A47 North Tuddenham to Easton

Scheme Number: TR010038

9.4 Draft Development Consent Order - Schedule of Drafting Changes for Deadline 3

**DRAFT DEVELOPMENT CONSENT ORDER:
SCHEDULE OF DRAFTING CHANGES FOR DEADLINE 3**

DRAWING TITLE  
**CLASSIFICATION OF ROADS PLANS REGULATION 5(2)(o) SHEET 10 OF 23**

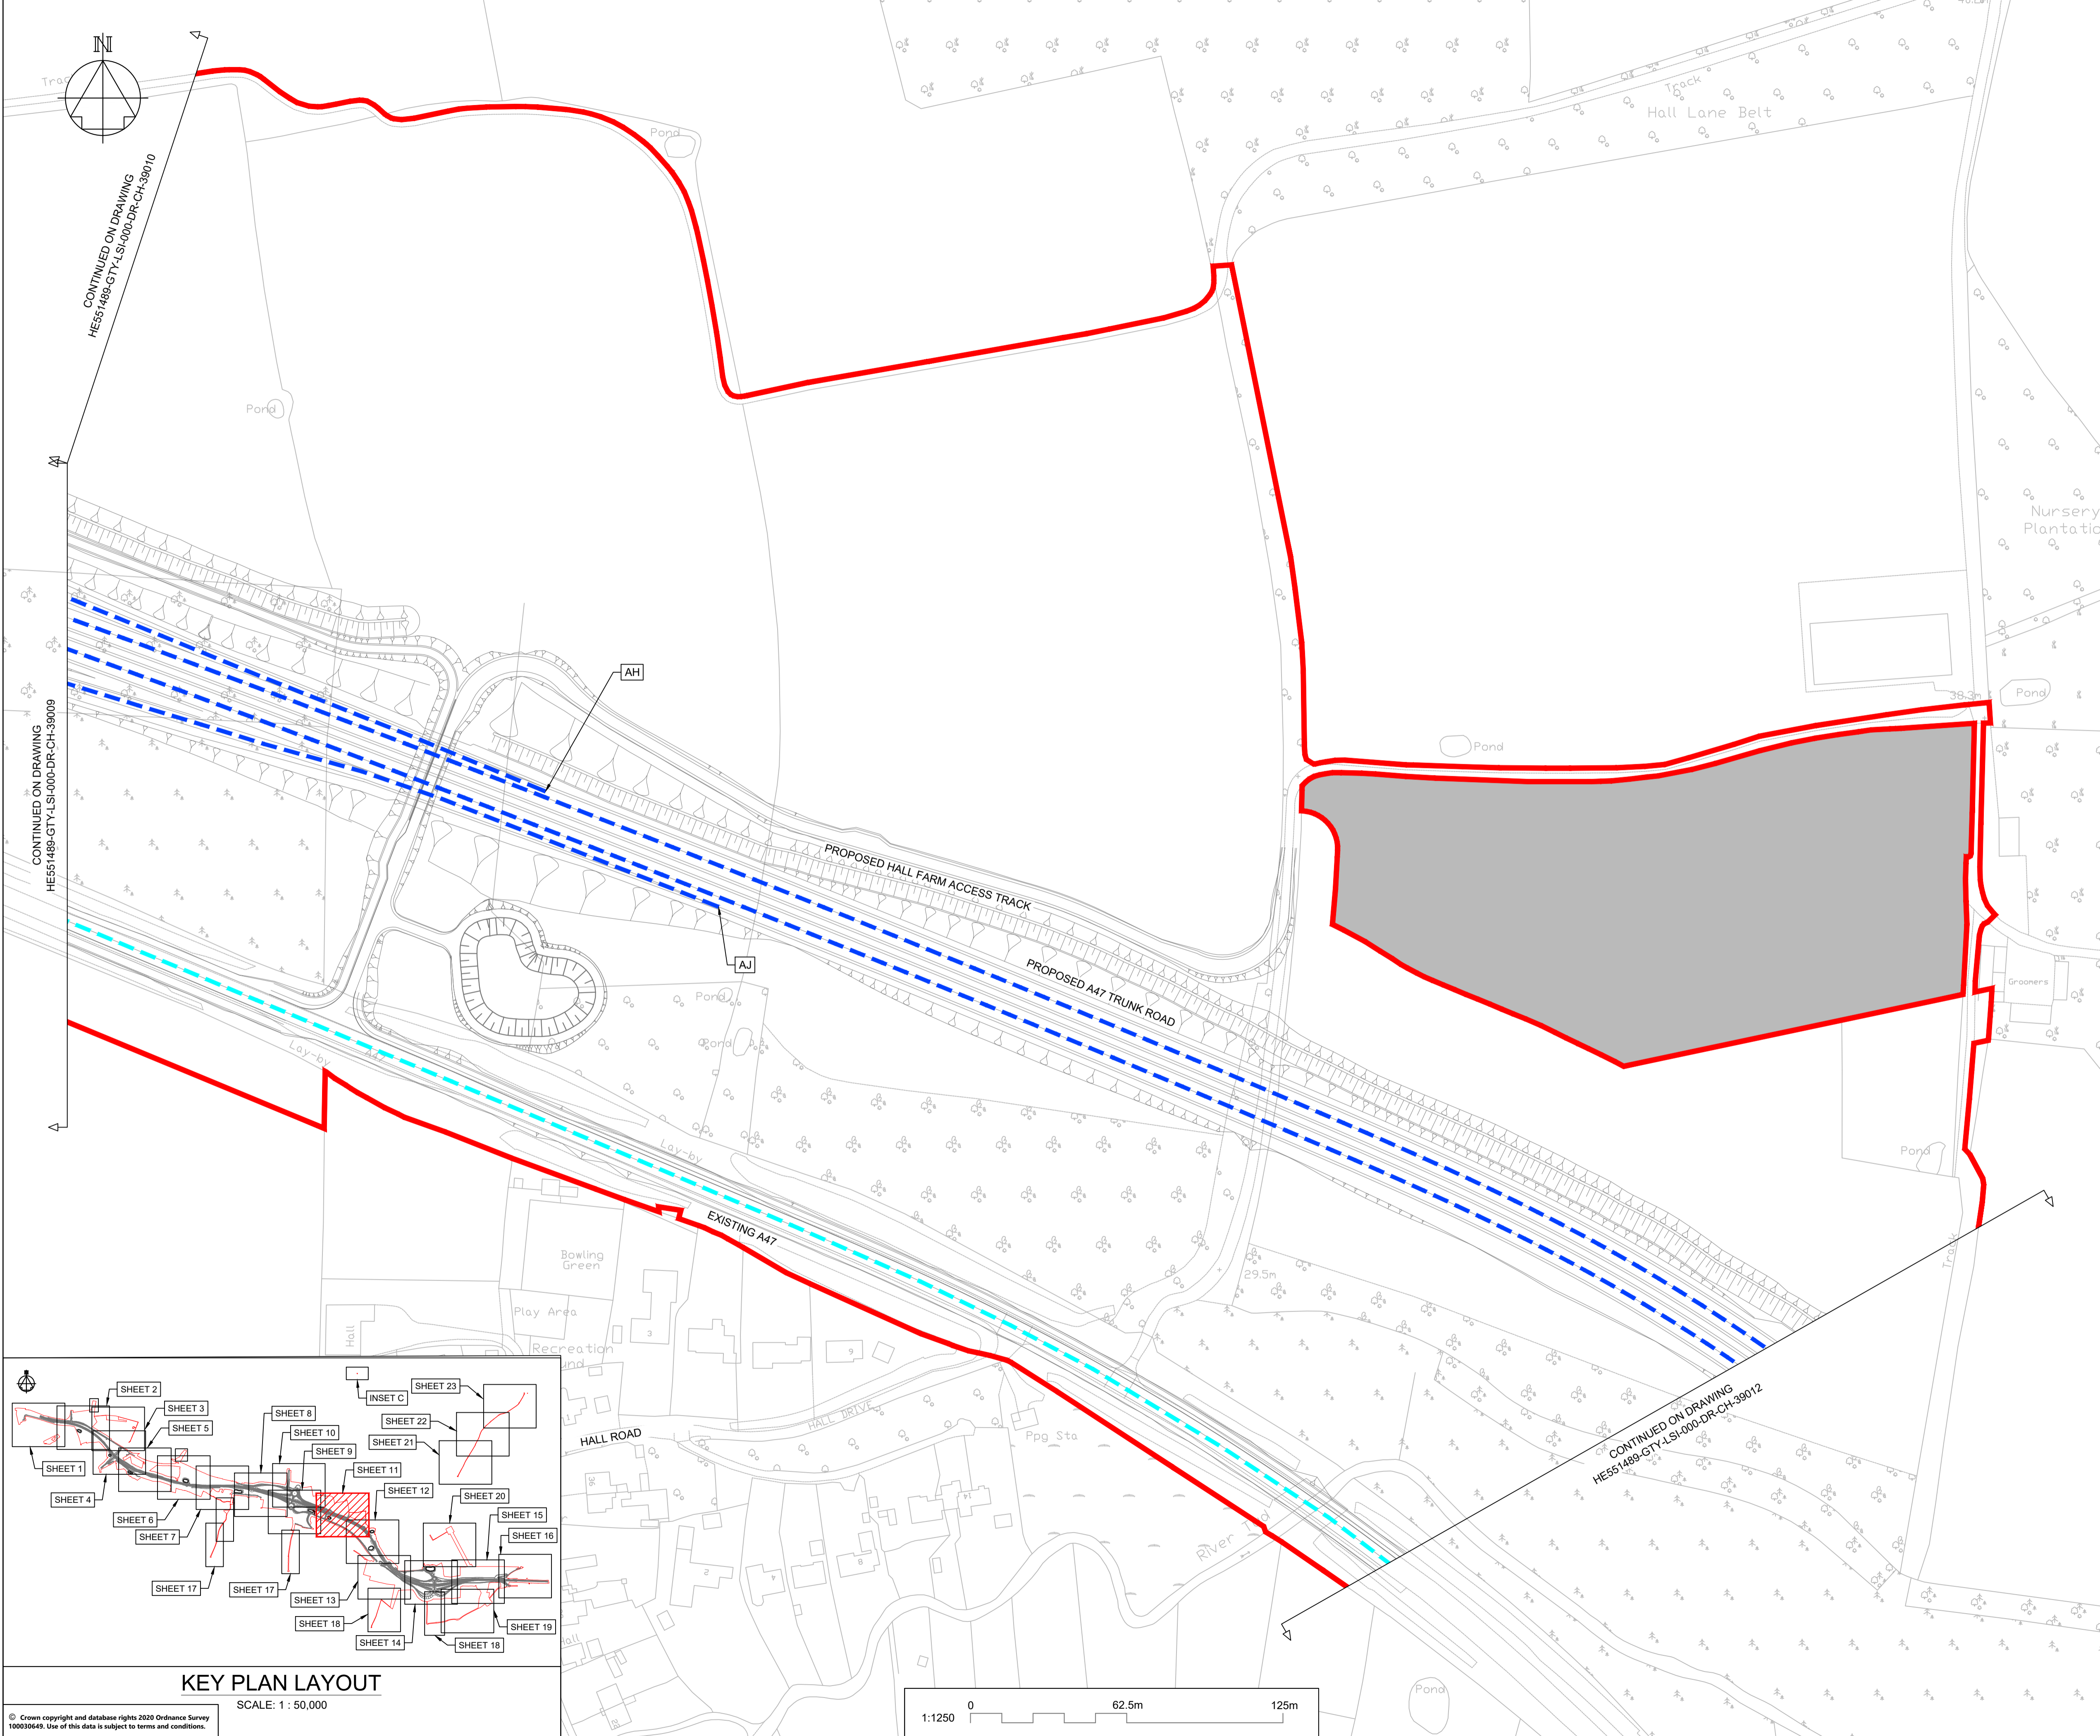
Schedule 3, 'Classifications of Roads', Part 4, The traffic regulation plans – sheet 10	The number "60" has been deleted and replaced with "50".	The speed limit has been reduced in accordance with the Applicant's response to Norfolk County Council's comments in RR037.11.	N/A	N/A
Schedule 3, 'Classifications of Roads', Part 4, The traffic regulation plans – sheet 14	The number "60" has been deleted and replaced with "30".	The speed limit has been reduced on safety grounds following discussions with Norfolk County Council.	N/A	N/A
Schedule 3, 'Classifications of Roads', Part 4, The traffic regulation plans – sheet 14	The number "60" has been deleted and replaced with "30".	The speed limit has been reduced on safety grounds following discussions with Norfolk County Council	N/A	N/A
Schedule 3, 'Classifications of Roads', Part 6, The rights of way and access plans – sheet 7	The first row "East Tuddenham Parish; Reference CF39 to CF40 A cycletrack in the verge on the southern side of the Link Road from the existing A47 from point CF39 to CF40, a distance of 50 metres" has been deleted.	Following a review of the cycle track provision, this has been deleted because the cycle track is to be provided in the northern verge of the existing A47	N/A	N/A
